Rezoning Transportation Analysis
Petition Number: Insert Zoning Petition #2021-018
General Location Identifier: Tax ID 07908301

Revision Log:

Date	Description
02-25-21	First Review (EL)
03-25-21	Second Review (KP)
04-27-21	Third Review (EL)

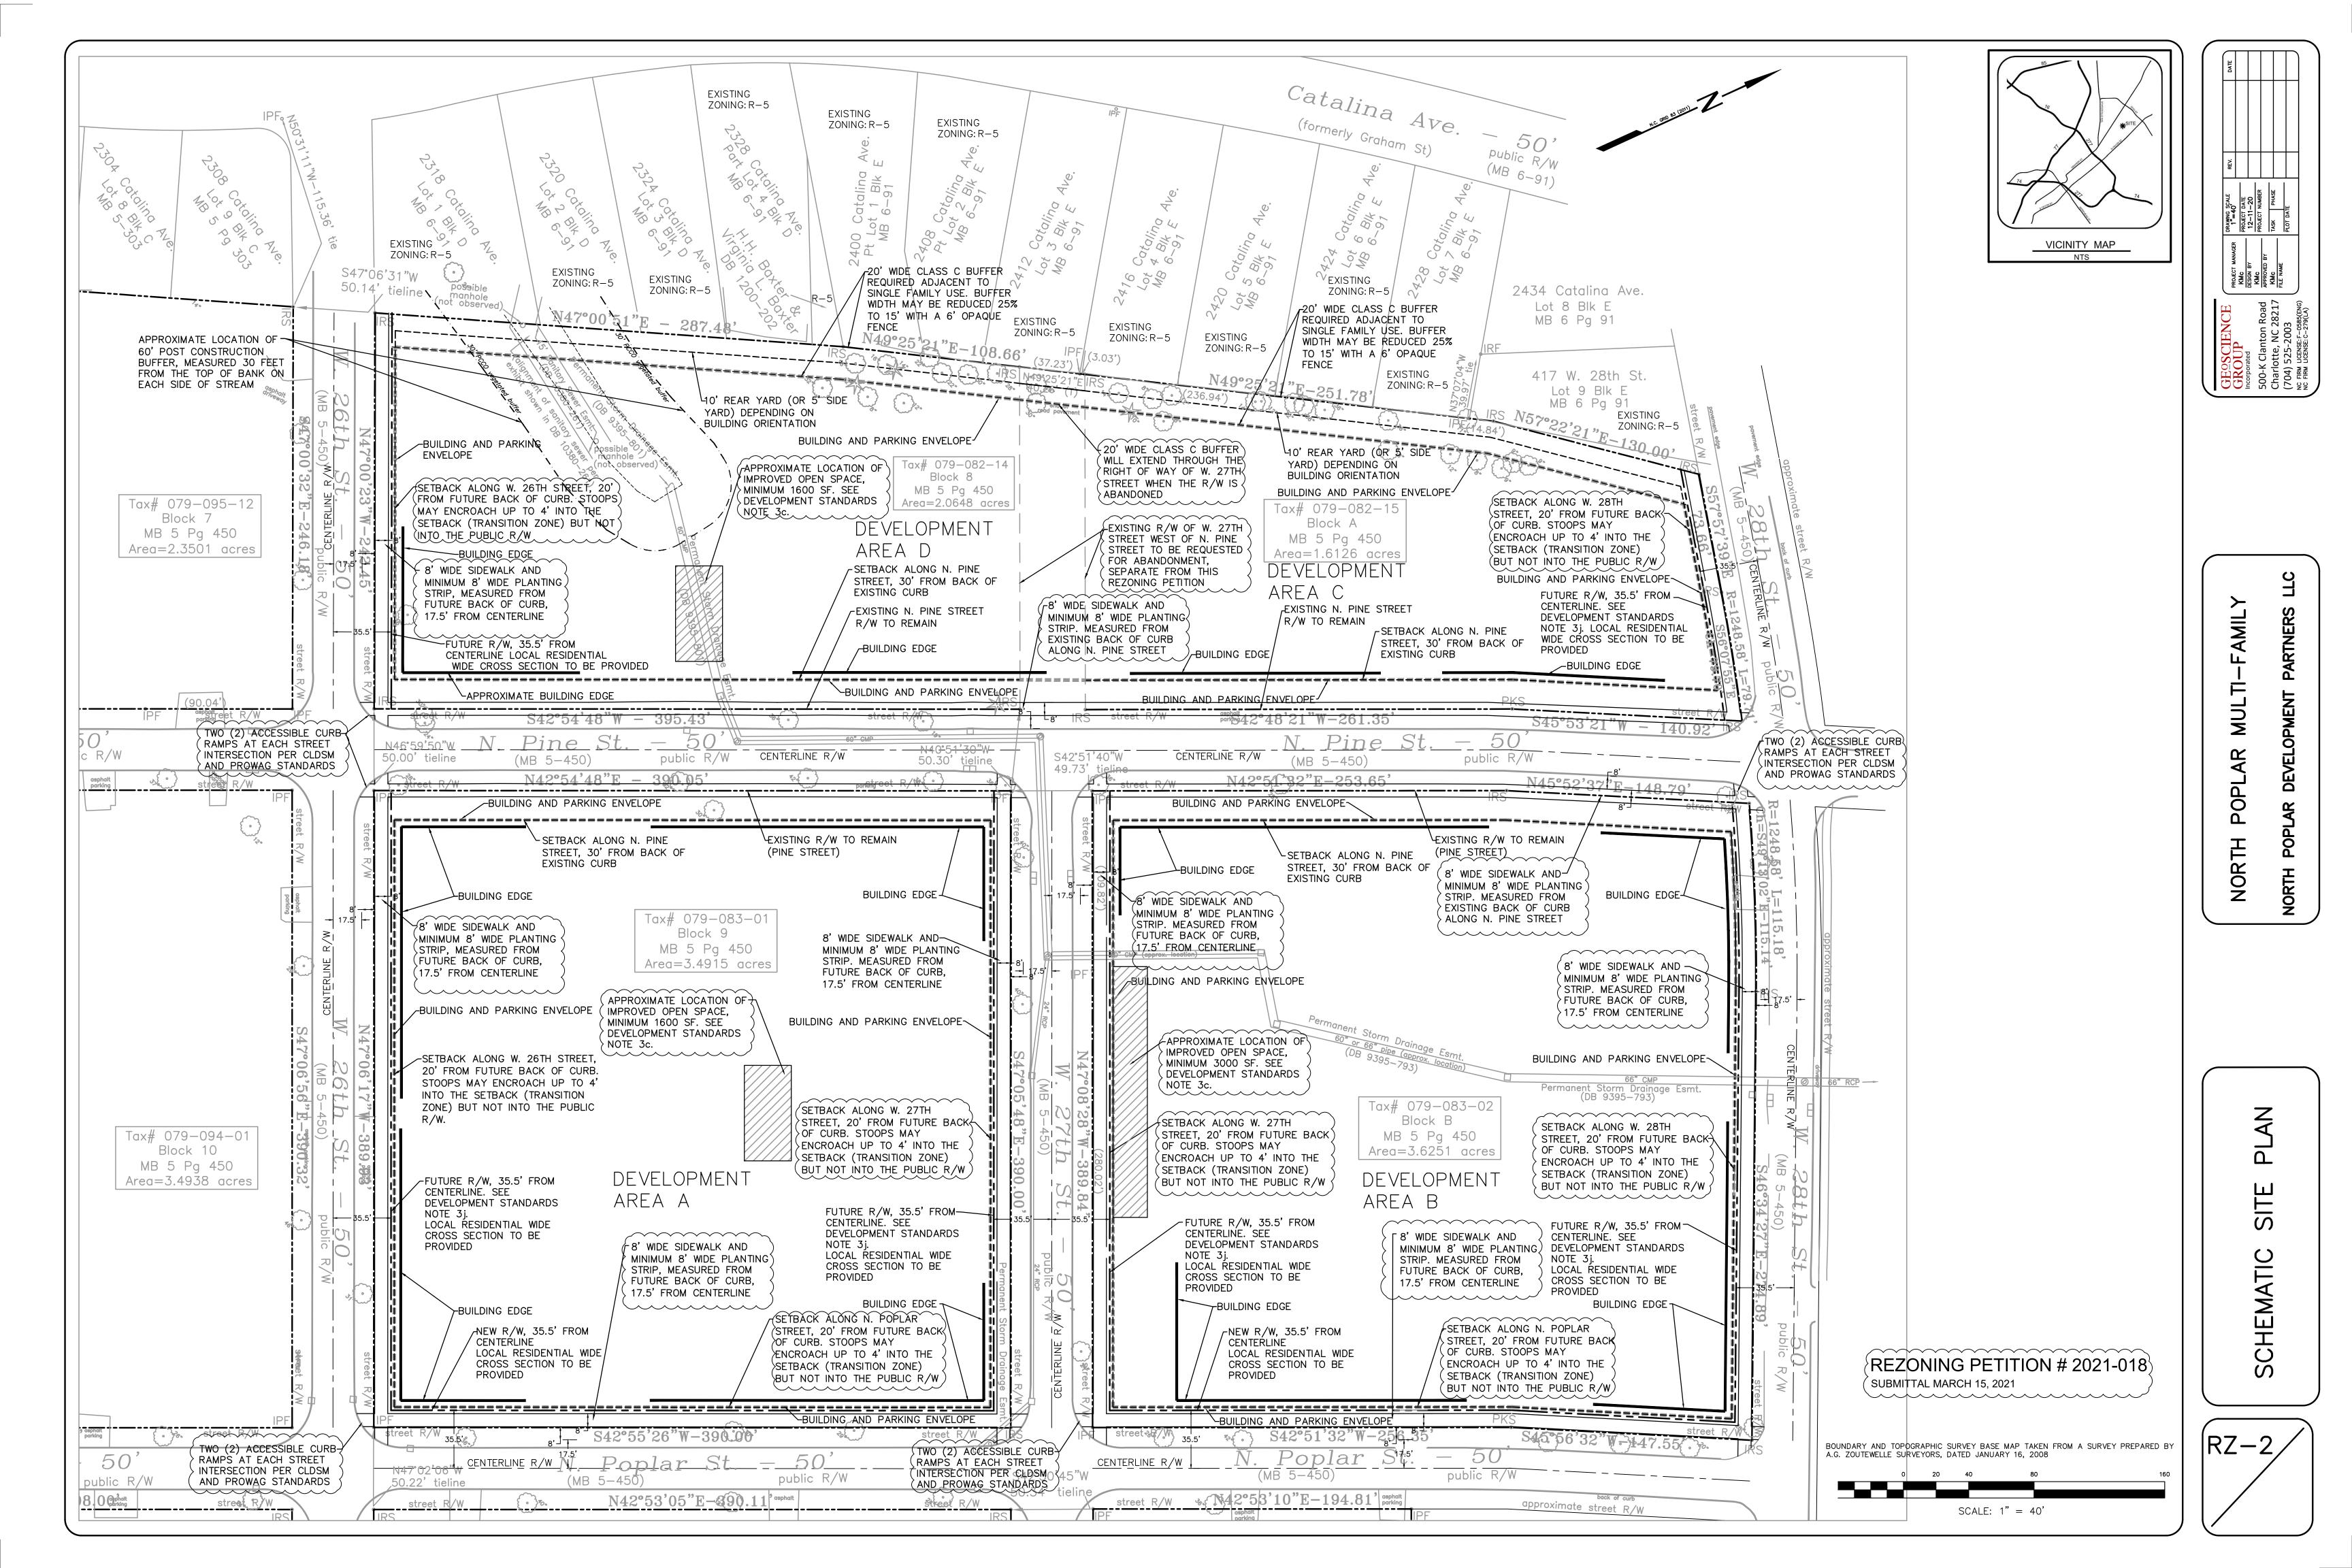
7. On sheets RZ-1 and RZ-2, remove call-out to abandon and remove W. 27th Street. Also, remove the site conditional note 3. Access, Buffers, Screening, Open Space and Pedestrian Circulation, Note I. The abandonment of W. 27th Street is not consistent with the USDG Standards (see image below).

Update to Comment as a Result of 03/16/2021 Site Plan: Remove note 3.K. This is covered in the site plan call-out, and is a separate process from the rezoning.
